04/02/2020

86-100 Mount Street Redevelopment (MP08_0241-Mod-10)
Request for Amendments

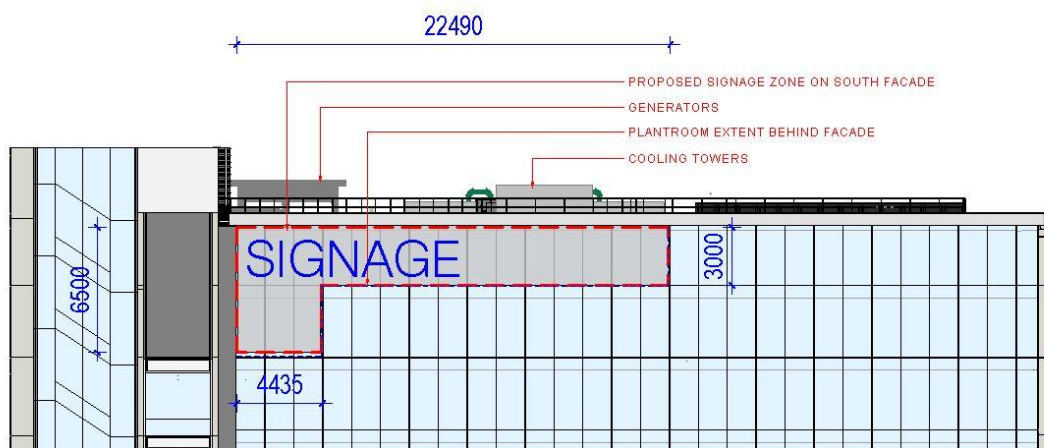
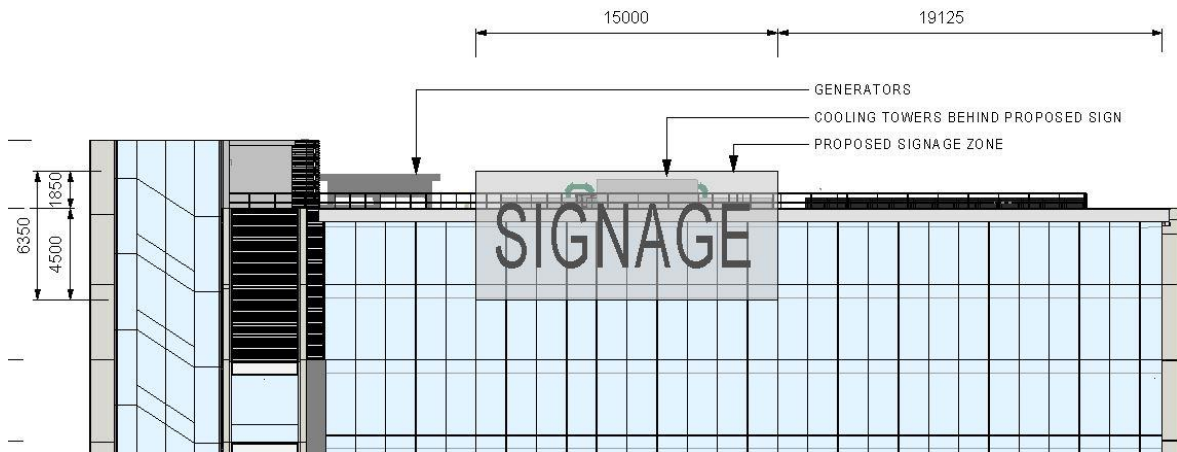
I refer to the above modification application for 86-100 Mount Street, North Sydney, and today's discussion with Murray Donaldson from Urbis. After careful consideration of the proposal, the Department requests that you review the location of the proposed signage zone on the southern elevation of the building.

The Department considers that the proposed signage zone should not protrude above the parapet height, so that it does not visually dominate the skyline and is well integrated into the design of the building.
